Planning Application Ref: **WA/7/19/RES**

Location: **Lanes End, West Walberton Lane, Walberton, BN18 0QS**

Description of works: **Approval of reserved matters following outline consent WA/26/18/OUT for layout & scale for 6no. dwellings & 6no. detached garages**

PJ DEVELOPMENTS LTD 2 Square Chambers 23 High Street Emsworth PO10 7AQ Tel: 0843 289 3430 Email: enquiries@pjdevelopmentsltd.com	
PROJECT: FORMER LANES END	
SITE PLAN OUTLINE PLANNING APPLICATION	
DATE: JANUARY 2019	DWG. NO 19-001 PL02
SCALE @ A1: 1:200	
REV: C

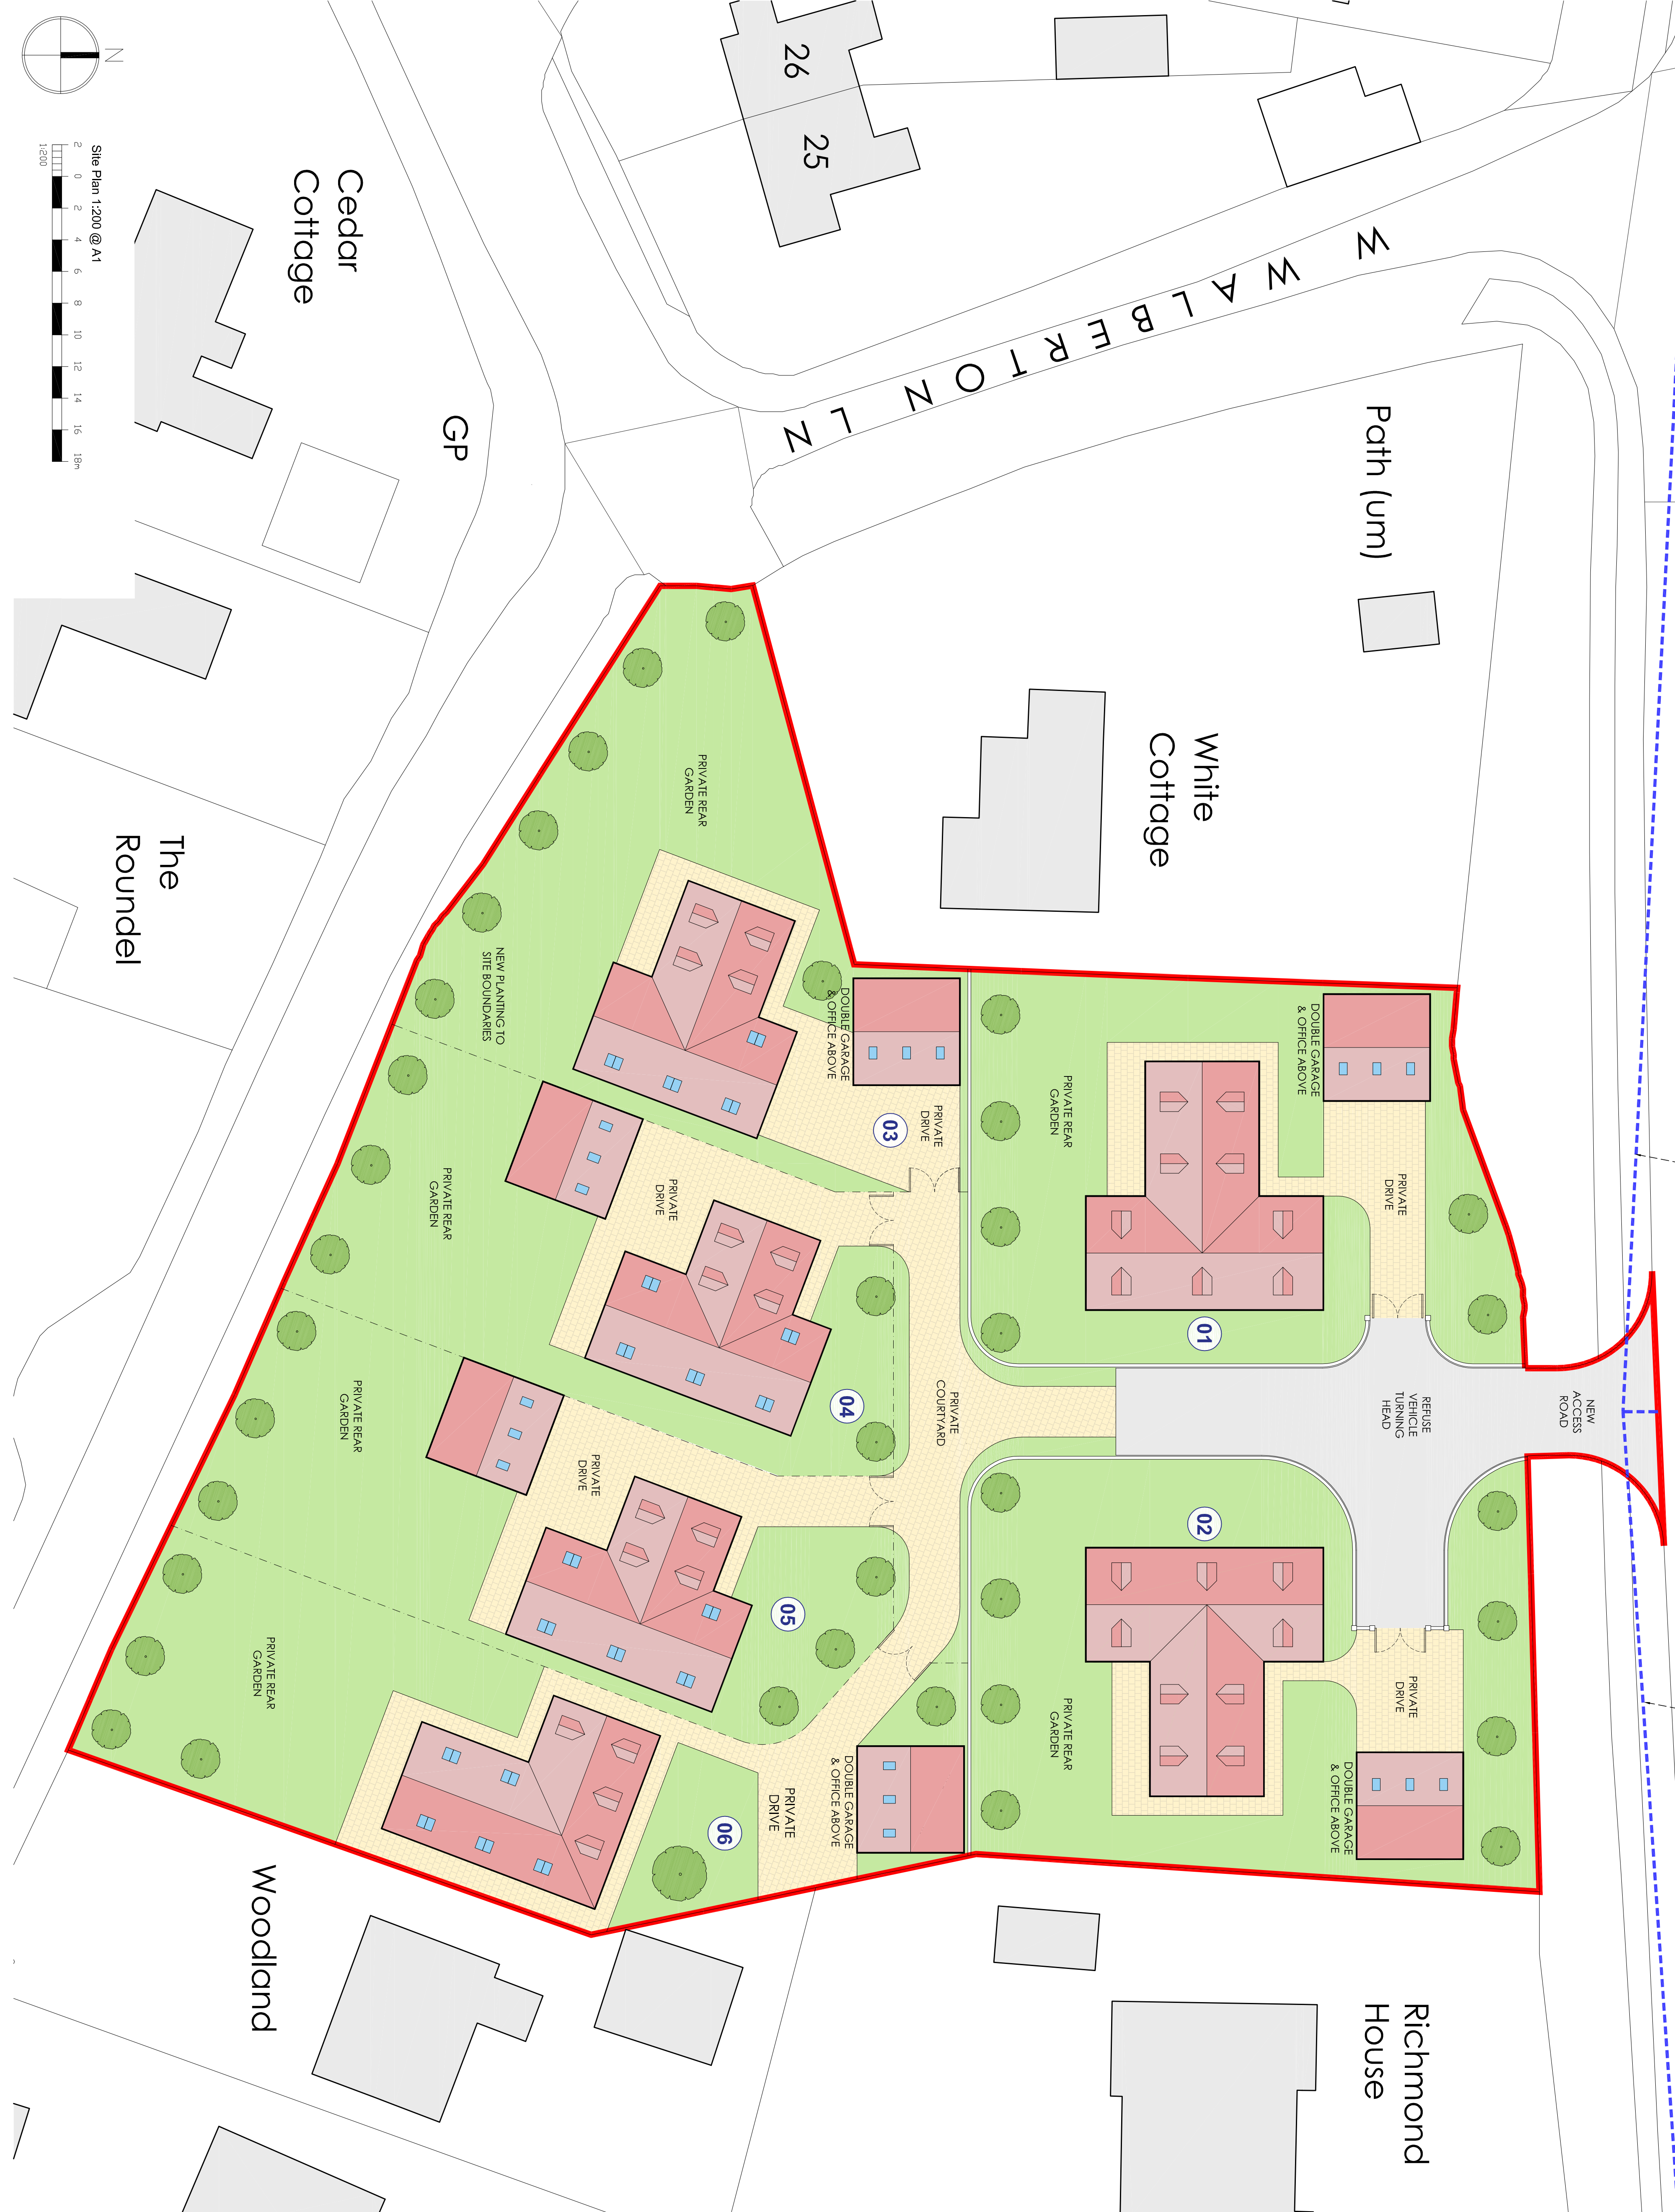
- In respect of site layout as indicated on the Block Plan, dwg. no. 19-001 PL-03, from PJ Developments Ltd, I can only make the following general comments:

- As a general principle of design, careful consideration should be given to the intended land use beneath existing canopy of established trees and the potential for further tree growth. With such a large and open site to work with I would expect a layout proposal to have placed great emphasis on eliminating future 'pressure to prune' of retained trees.

- Furthermore, there would need to be a compelling argument in favour of any Root Protection Area incursion as this site clearly lends itself to a harmonious design that avoids any direct interference with established trees of current and future landscape value. This is especially relevant where there are trees of high amenity, landscape and potential heritage value (which has already qualified them for statutory protection), as is the case here.

1. The applicants will need to employ the services of an Arboricultural Consultant to carry out a tree survey exercise and then prepare an Arboricultural Implications Assessment (AIA) which must be inclusive of; a 'Tree Survey Schedule', a 'Root Protection Area (RPA) Schedule' and a 'Tree Constraints Plan' – with the trees accurately plotted on same.
2. In the event that a RPA of any tree which is proposed for retention overlaps the development then BS5837:2012 requires that the Detailed Planning Application is accompanied by an Arboricultural Method Statement (AMS) and also most importantly a Tree Protection Plan – to both describe and illustrate the mitigation measures which are to be employed to ensure that the trees survive without detriment to their vigour and vitality and are given adequate protection both above and below ground.
